PROJECT TITLE: Service Master of Abq ZONE ATLAS/DRNG. FILE #: G-16-Z

RE: *SERVICEMASTER (G16-D57B). ENGINEER'S CERTIFICATION FOR
CERTIFICATE OF OCCUPANCY. ENGINEER'S CERTIFICATION DATED MARCH 3,
1997.*

**RE: REVISED DRAINAGE PLAN FOR SERVICE MASTER OF ALBUQUERQUE
(G16-D57B) REVISION DATED 10/10/96.**

RE: Drainage Plan for Service Master of Albuquerque (G16-D57B) Engineer's stamp dated 9/13/96.

Grading and Drainage Plan

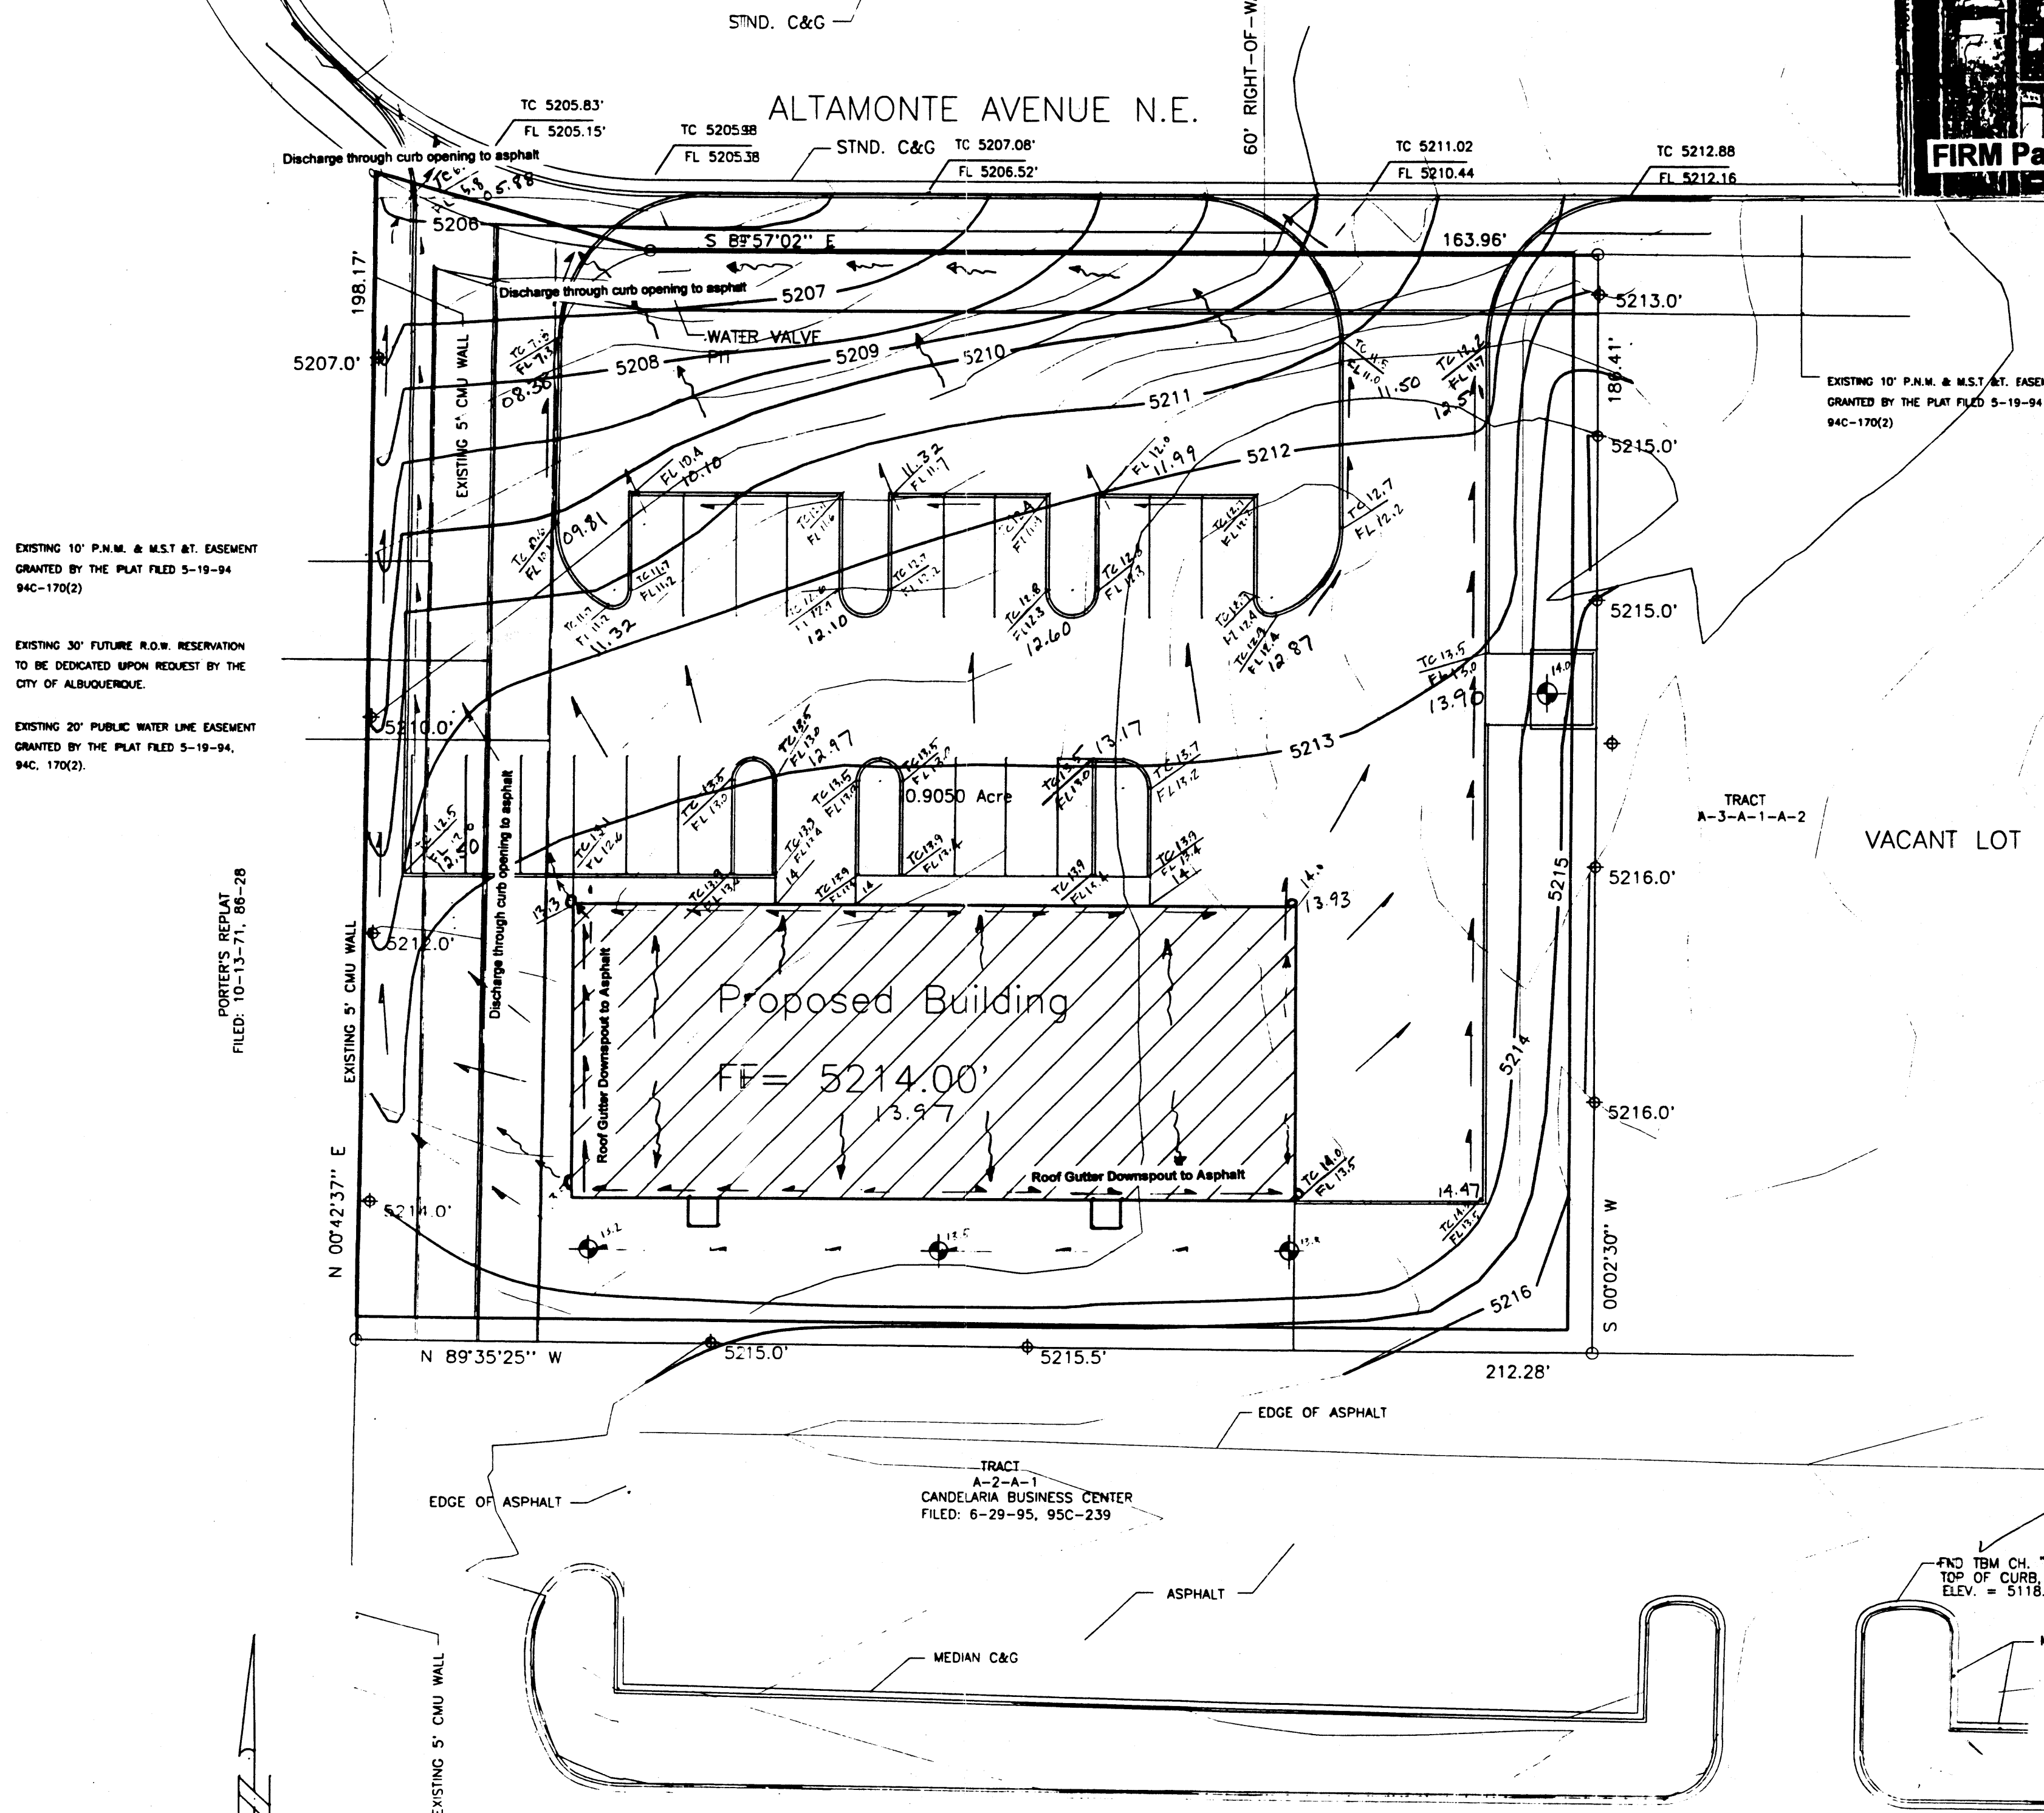
1. The Engineer's Certification statement must show your P.E. number. You may either indicate your P.E. number below your typed name or place your stamp next to the statement. As you have correctly done, the statement must be signed and dated.
2. The last sentence of your statement should say "to in substantial compliance with the approved plan." Please replace "within" with "in" and add the words "approved plan."
3. Provide the City address for this project. I need the street name and number to complete the Certificate of Occupancy.

Grading and Drainage Plan

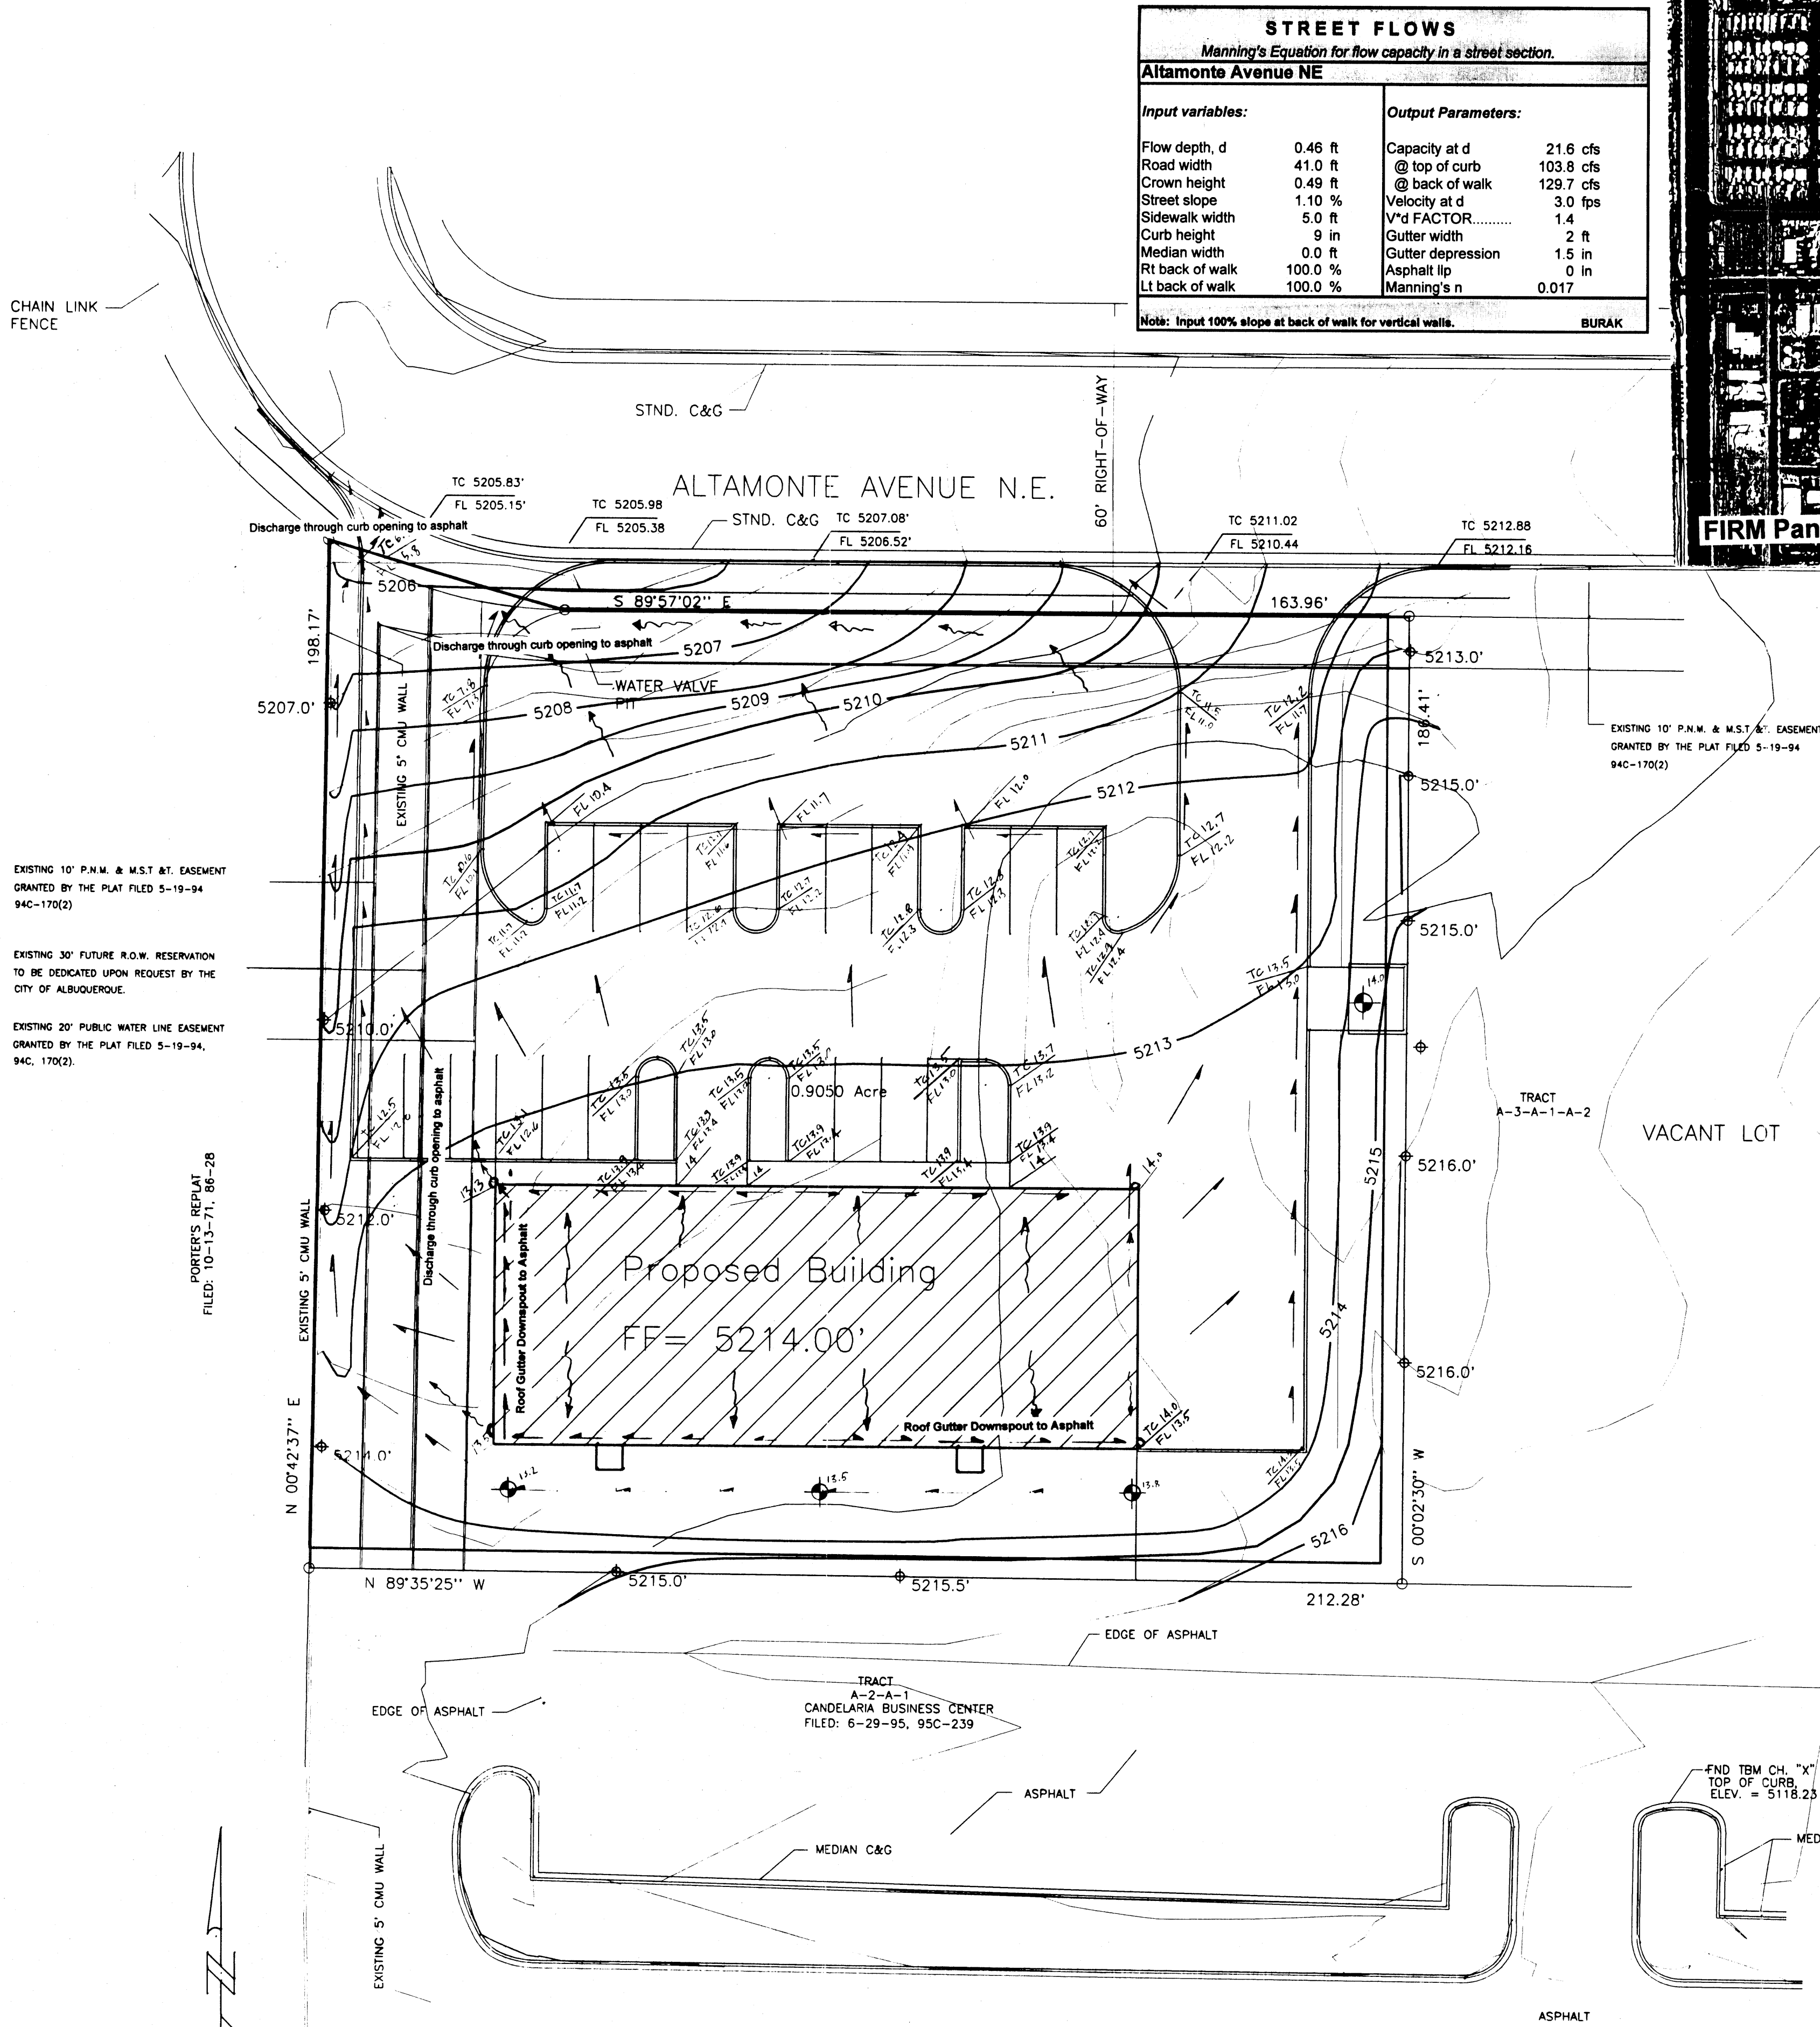
1. Roof runoff from the south portion of the lot must be routed to the asphalt area and eventually out through the drive pad. Your plan drawing indicates otherwise. No developed runoff is allowed over a public sidewalk.
2. What C.O.A. Benchmark was used to establish the T.B.M.? Give location & elevation.
3. If the roof runoff is routed onto a landscape area, provisions must be made to allow for the runoff to outlet onto the asphalt areas.
